**ADC Planning Consultation
Response from the Historic Buildings Adviser**

Application Number	BE/137/12/L
Address	76 North Bersted Street, Bognor Regis
Description	Replace/refurbish windows, maintaining identical appearance but adding double-glazed panes.
Case Officer	Janice Chapman
Site Visit

Photograph of front elevation of house, which faces west, showing the windows.
Scale approx 1:50 at A4

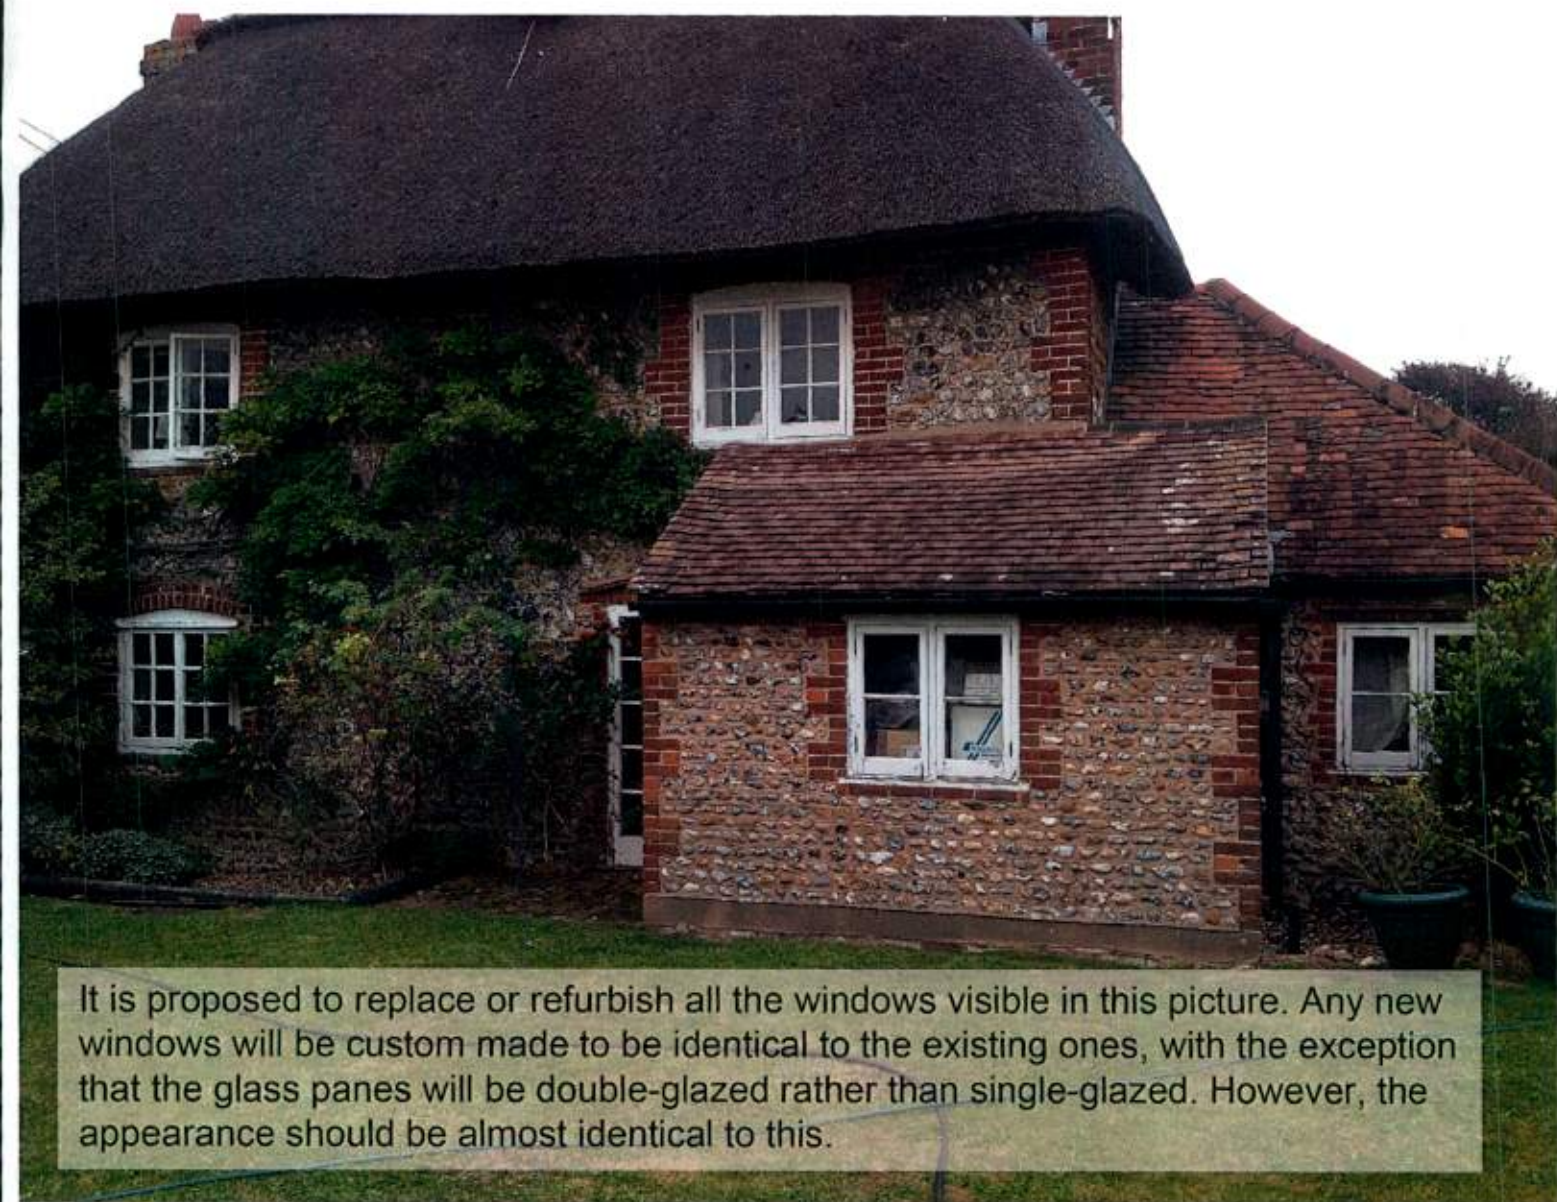
As a general rule double-glazing is not permitted in listed buildings. It introduces an integral feature to the historic building which detrimentally affects its appearance. This is especially the case with small multi-paned windows. This is not acceptable.

It should be noted that any variation in design of window may be an important feature of any historic building and its character. Rationalization to one design is therefore not necessarily positive or desired.

Secondary glazing can be installed and without the need for consent. Some secondary-glazing is very discrete and often considered better for noise reduction and draughts. Secondary-glazing is considered acceptable because it is a fitting which can easily be removed and does not become integral to the listed building. It also allows both the historic fabric (where it exists) and character of the historic building to be properly preserved. This plays an important part in retaining special interest, but also in promoting sustainability.
